# Final Plat OWL RIDGE SUBDIVISION

PART OF THE WEST HALF OF THE SOUTHWEST QUARTER OF SECTION 7, TOWNSHIP 11  
SOUTH, RANGE 65 WEST OF THE SIXTH PRINCIPAL MERIDIAN  
COUNTY OF EL PASO, STATE OF COLORADO

Civil Engineering • Land Surveying • Landscape Architecture  
www.smhconsultants.com  
Manhattan, KS - HQ P: (785) 776-0541 • Dodge City, KS P: (620) 255-1952  
Kansas City, KS P: (913) 444-9815 • Colorado Springs, CO P: (719) 465-2145  
Drawn By: JTH Project 2010CS4031 DD TDS87 PCD File # MS-22-005

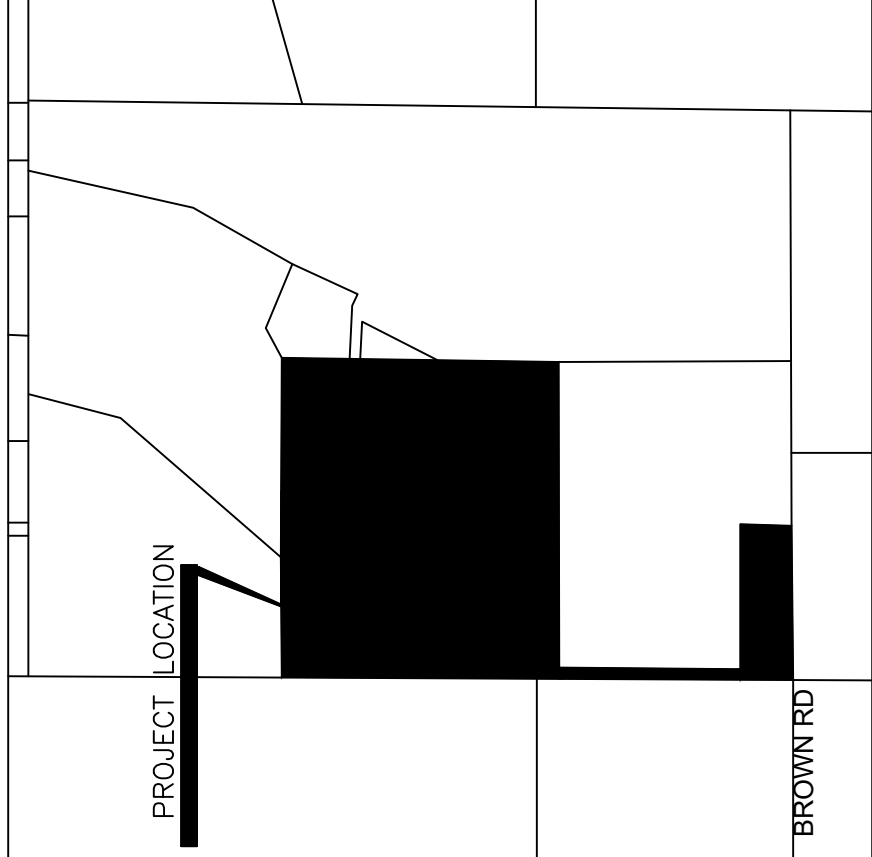
**Add the following:**

- Date of submission with provisions for dating revisions located in the lower right hand corner
- Name, address and telephone number of the owner of record in the lower right hand corner

- A statement by the land surveyor explaining the basis of bearing. Assumed bearings shall not be used. The existing monuments that define the reference line shall be included on the plat. One of the following methods of establishing a basis of bearing shall be used: (1) solar or polaris observation - the date of the observation and the method used shall be included in the basis of bearing note; or (2) GPS observations on the monuments at each end of the reference line (Note: The observations shall be of sufficient time to ensure an accurate bearing. The methodology and length of the observation session shall be included in the basis of bearing note

- The address of each lot as provided by the Pikes Peak Regional Building Department (added prior to recording)
- The final total gross acreage, the total number of lots, gross density, net density and net acreage of the subdivision.

Are there covenants as part of the two lot subdivision?
